# Gatwick Airport Northern Runway Project

Appendix G: Response to the JLAs' Comments at Deadline 4  
on the Noise and Vibration Technical Notes

**Application Document Ref: 10.38**

## 1 Applicant's Response to JLAs Comment on Supporting Noise and Vibration Technical Notes [REP3-071]

Appendix 2: Slow Transition Fleet Noise Contours

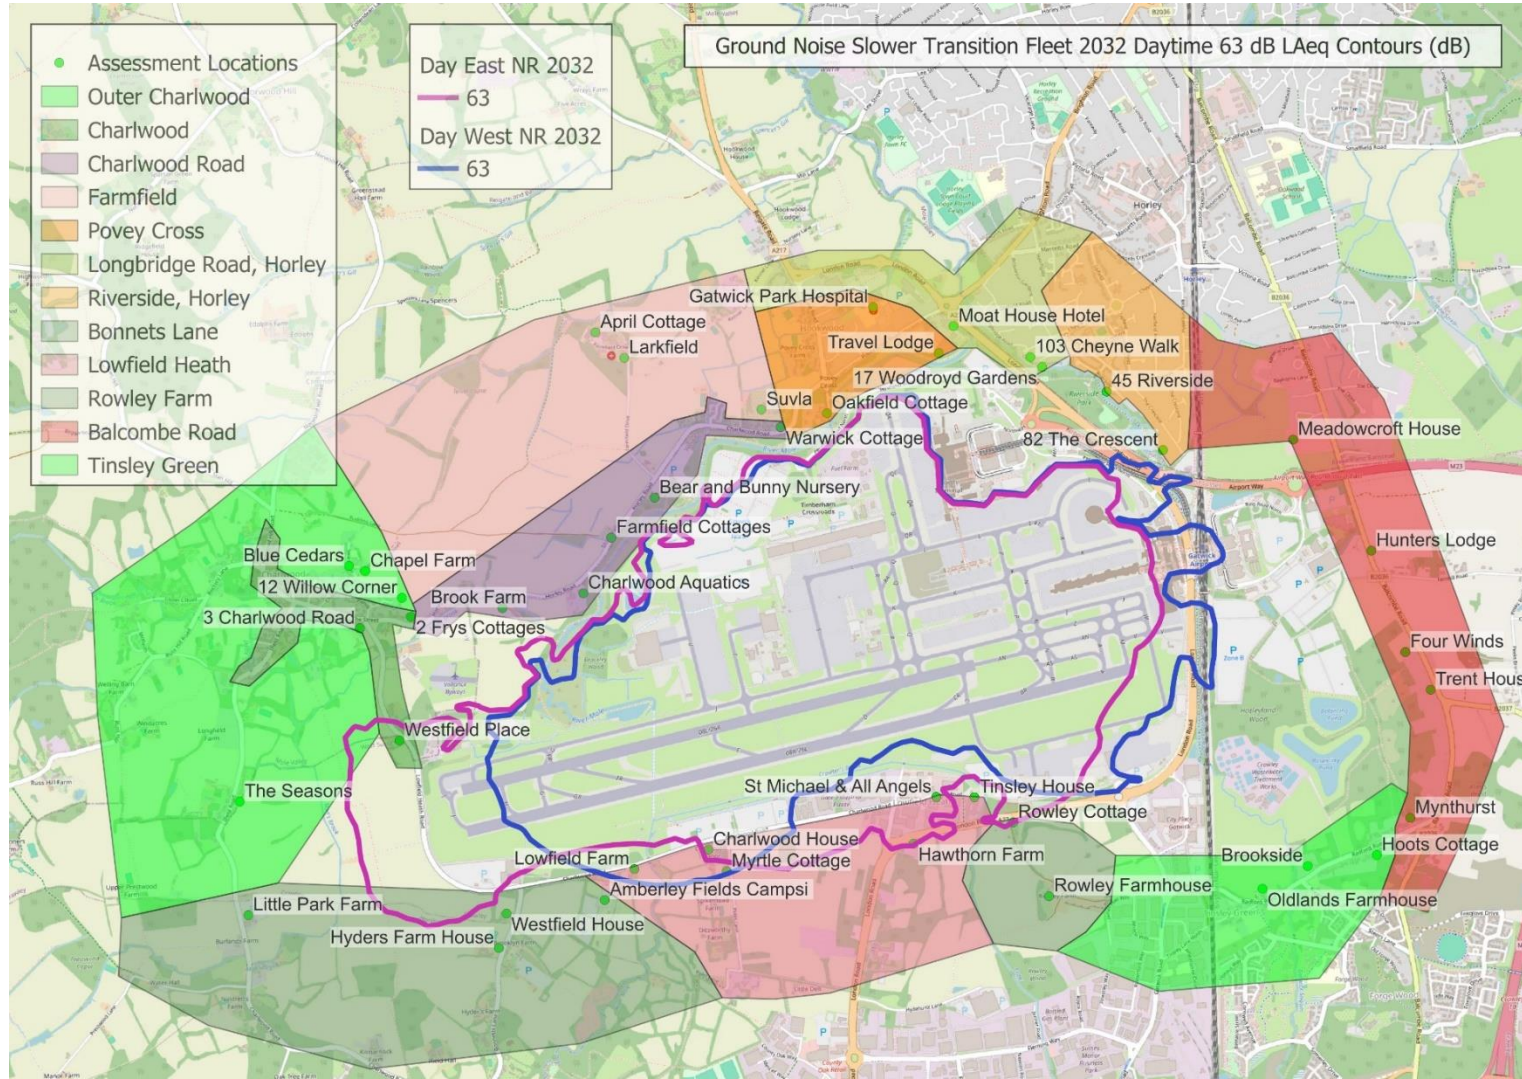
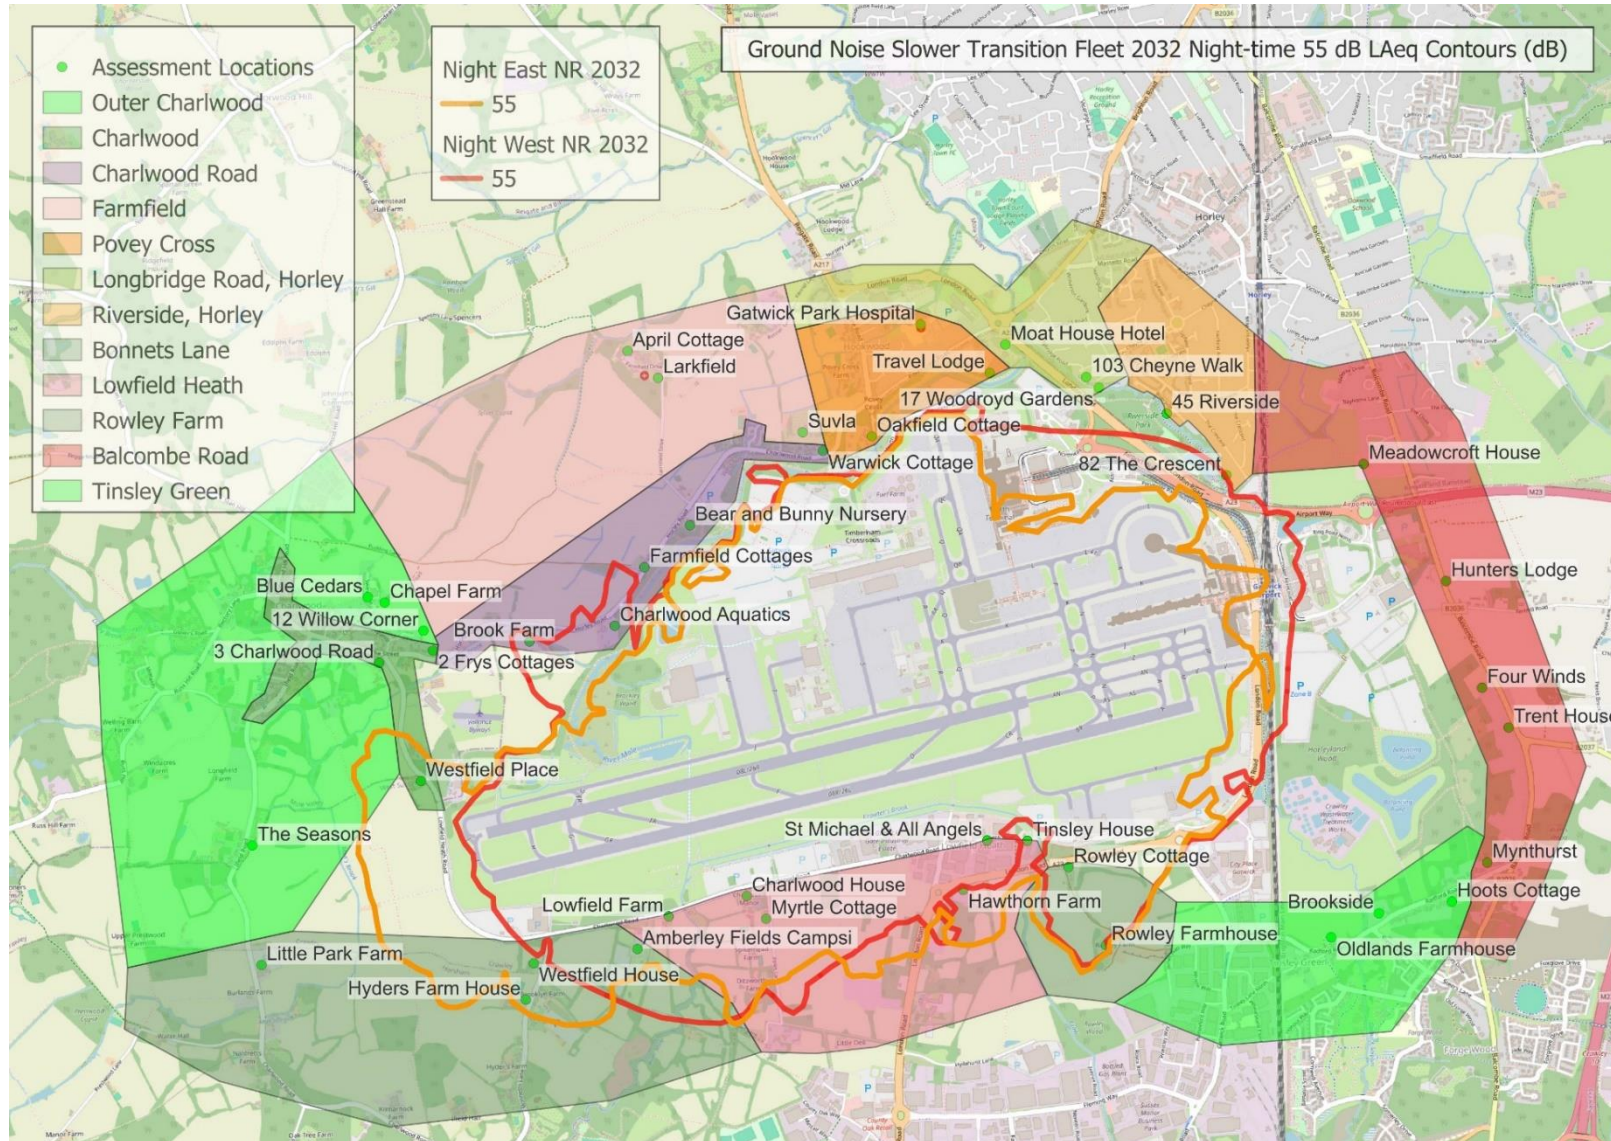
<p>EA320NEO aircraft from the central case with approximately 200 B73710MAX aircraft.</p> <p>The Applicant should explain why the fleet composition of the slower transition case is so markedly different than the central case fleet and why the central case and slower case contours do not converge in 2047.</p> <p>Following on from this, it is important to understand how the fleet are modelled. The JLAs have requested that the Applicant provide details of their validation process along with SEL/LAmax baseline data for individual aircraft variants at each monitoring location. This request was originally made after the JLAs review of the PEIR and subsequent requests have been ignored by the Applicant. The JLAs would urge the Examining Authority to request the Applicant provide this information as it is important for understanding how individual aircraft</p>	<p>accurate as it can be when undertaking such a forward looking assessment, and it will also be subject to further scrutiny through review in the future to ensure its robustness.</p> <p>With regards provision of information on modelling aircraft noise, the Local Authorities have agreed 'The use of ANCON is not disputed' (10.1.1 Statement of Common Ground between Gatwick Airport Limited and Crawley Borough Council point 2.13.5.2). Model validation data has been provided. The CAA's Environmental Research and Consultancy Department (ERCD) presented a sample of SEL and Lmax data to the Noise Topic Working Group on 7 June 2022 demonstrating the model validation process. Extracts from the slide deck circulated and presented to the group are included in Annex 1, below. Therefore, there is no requirement for ERCD to provide this.</p>

Diagram 2: ES Noise Model (Scenario 1)

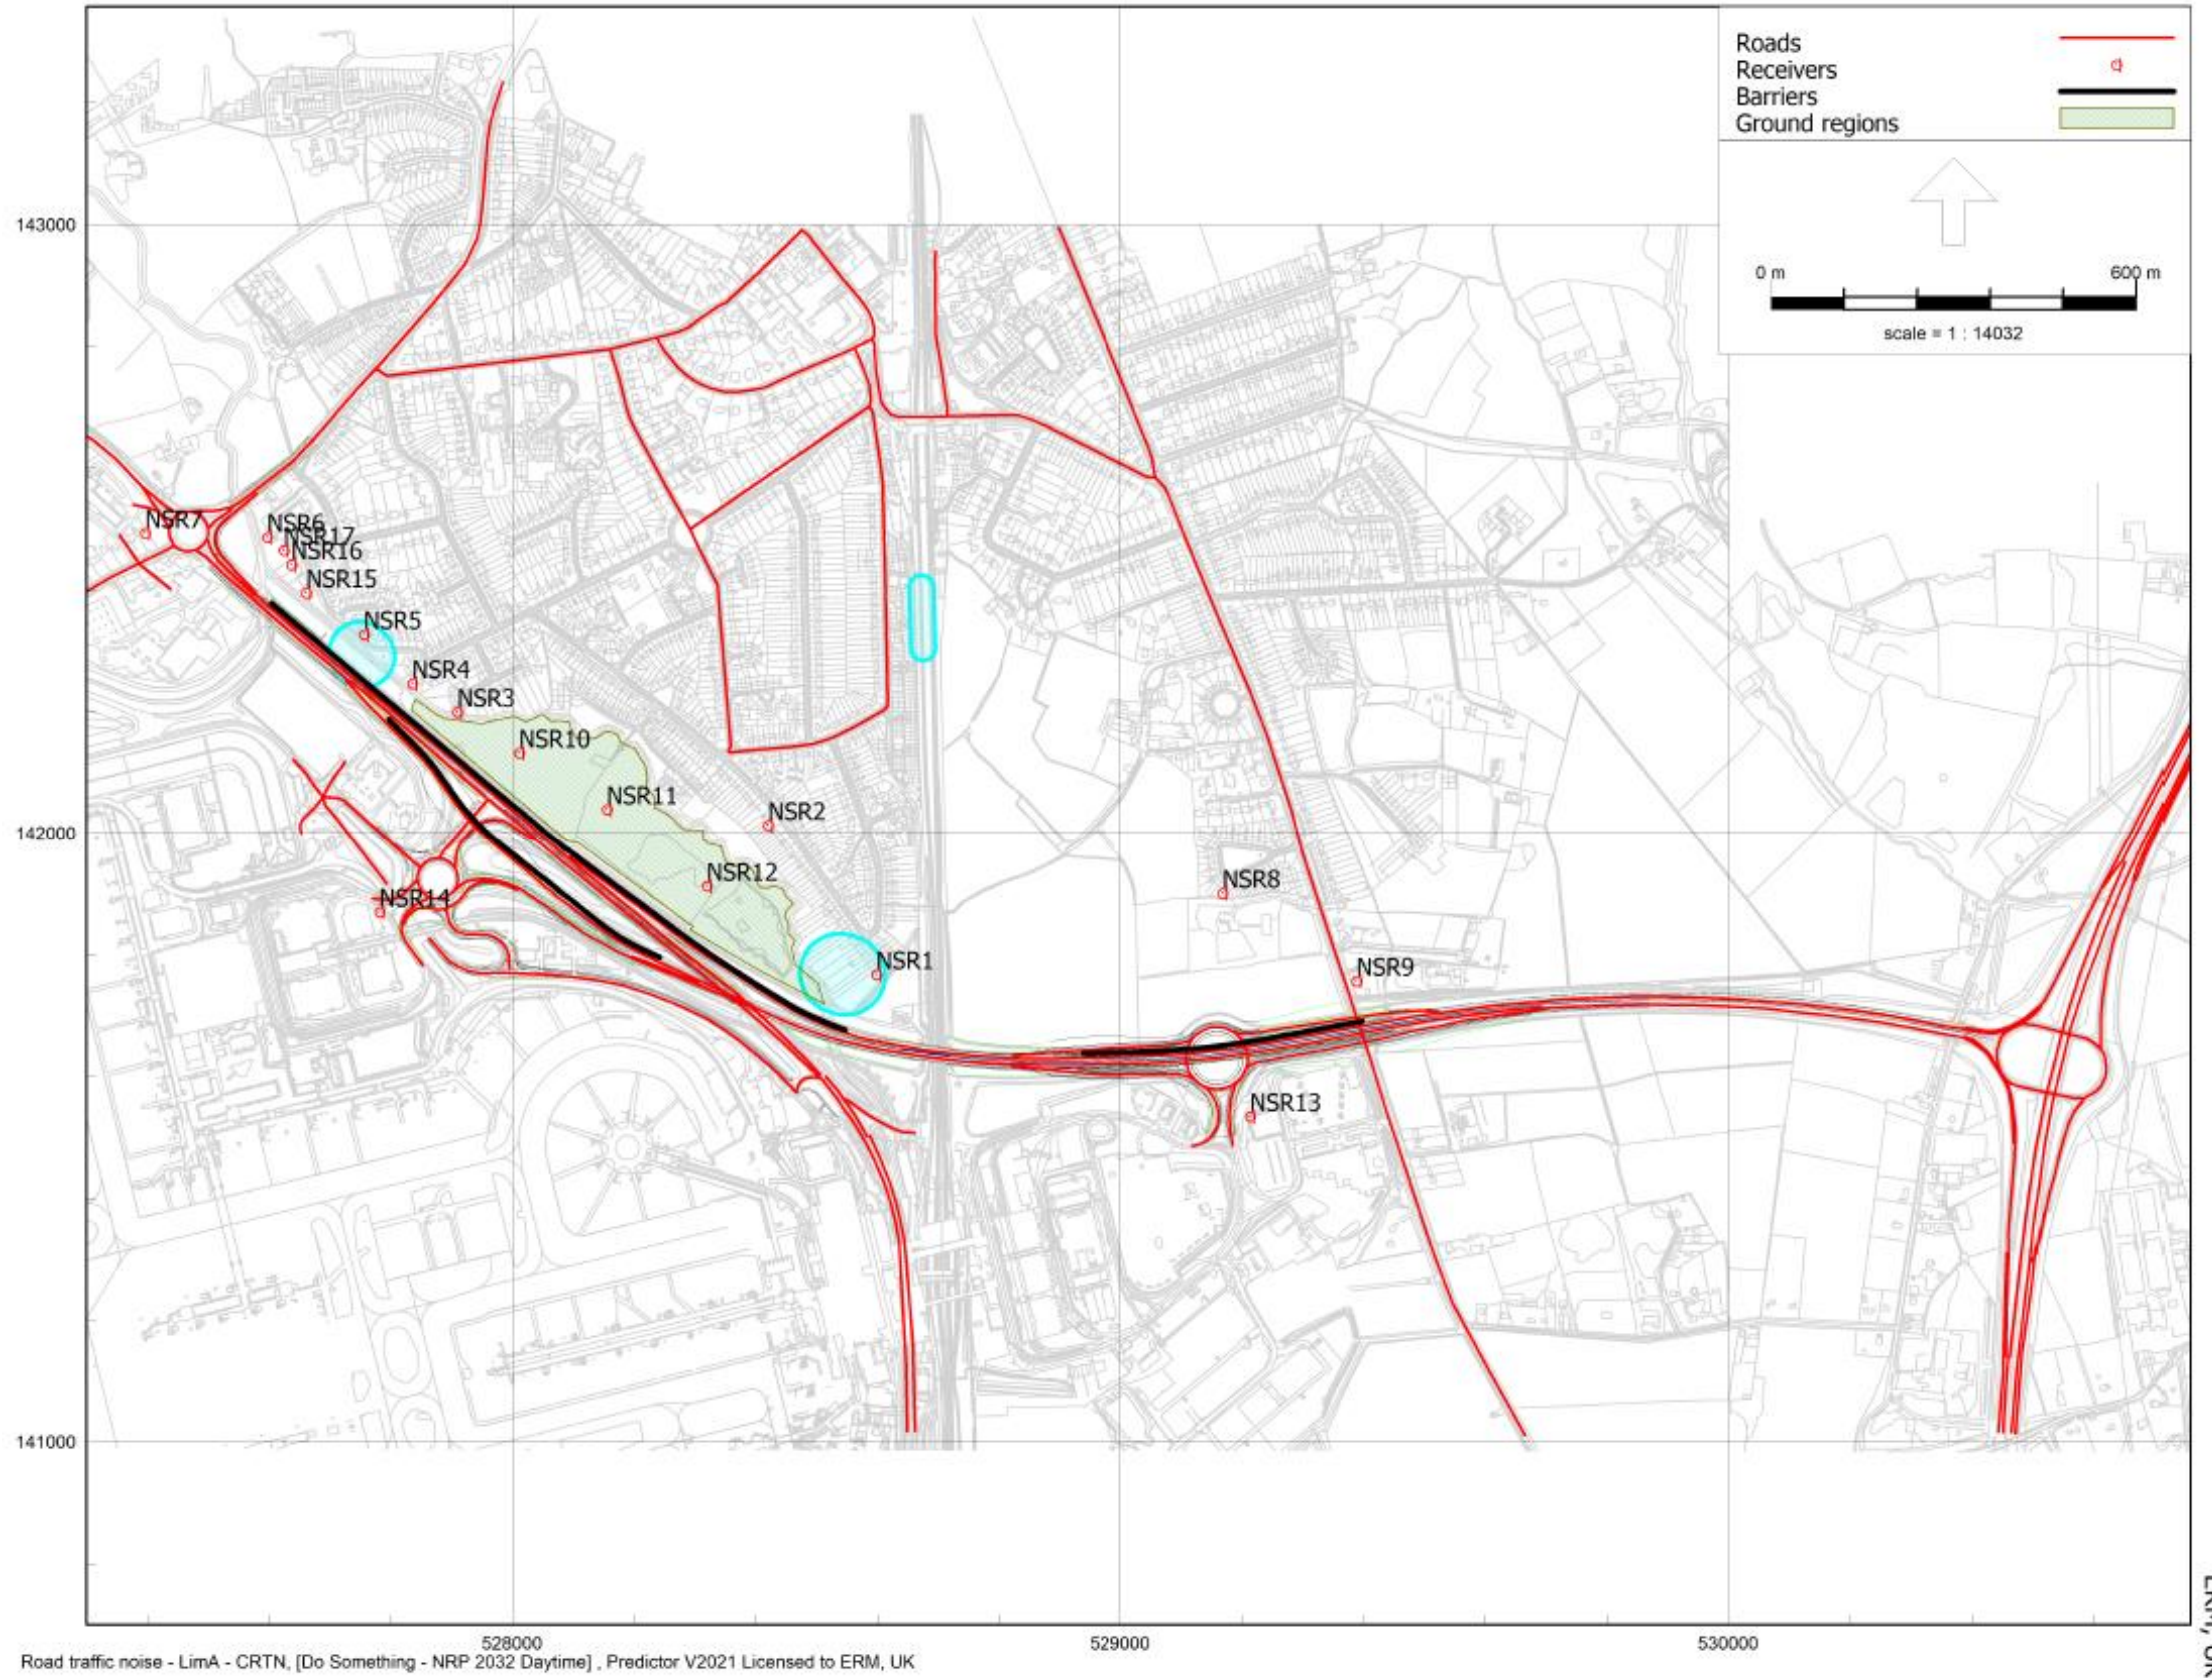
JLA-NVTN-C3	Table 2	Traffic noise predictions	<p>A review of the traffic noise predictions was undertaken and the JLAs noted that the predicted ES road traffic noise levels in Table 2 did not match the ES predictions from Table 6.3.1 of ES Appendix 14.9.4 <a href="#">[APP-174]</a>. They do match the results of the road traffic noise mitigation analysis in Table 5.1.1 of ES Appendix 14.9.4 <a href="#">[APP-174]</a>. The JLAs would like to query why the results of Table 5.1.1 and Table 6.3.1 are different for baseline scenarios with specific focus on the 2018 baseline, which should be</p>	<p>Table 2 is incorrectly titled as presenting ES road traffic noise levels. It presents the results of the assessment carried out between the PEIR and the ES, to inform the design process for the ES stage, which was reported in a Noise Barrier Note shared with the local highways and planning authorities in August 2022 (and is also reported in the ES Appendix 14.9.4 <a href="#">[APP-174]</a> at Table 5.1.1).</p> <p>Similarly, the heading at paragraph 3.2.5, which refers to 'the ES stage' would be clearer if it instead referred to modelling carried out between the PEIR</p>

<p>unaffected by traffic forecasts and mitigation.</p> <p>and the ES.</p> <p>The baseline values reported in ES Appendix 14.9.4 <a href="#">[APP-174]</a> Table 5.1.1 and Table 6.3.1 are slightly different because the Traffic and Transport team revised their strategic modelling outputs between the PEIR and the ES. The final ES noise modeling showed very similar noise levels to those after the PEIR and the justification for not including the Riverside Garden Park noise barrier was the same.</p>
<b>Appendix D – Traffic Noise Important Area Assessment</b>			
JLA-NVTN-D1	4.1.2	2032 is the most stringent assessment	<p>Can the Applicant explain why 2032 is considered as the most stringent assessment for road traffic noise when, for similar projects, the worst-case assessment tends to be when aircraft movements are at their maximum</p> <p>The ES assesses road traffic noise effects in 2032 (the year of opening) and 15 years later, in 2047, as required by the Design Manual for Roads and Bridges (DMRB). 2032 is considered the most stringent assessment year because the significance of road traffic noise effects is predicted to be higher than in 2047, following the methodology in DMRB which indicates a Minor effect for noise increases of 1dB or more in the short term and 3dB or more in the long term.</p> <p>The results of the DMRB assessment for both 2032 and 2047 are presented in ES Appendix 14.9.4 <a href="#">[APP-174]</a>. The effect of the noise mitigation</p>
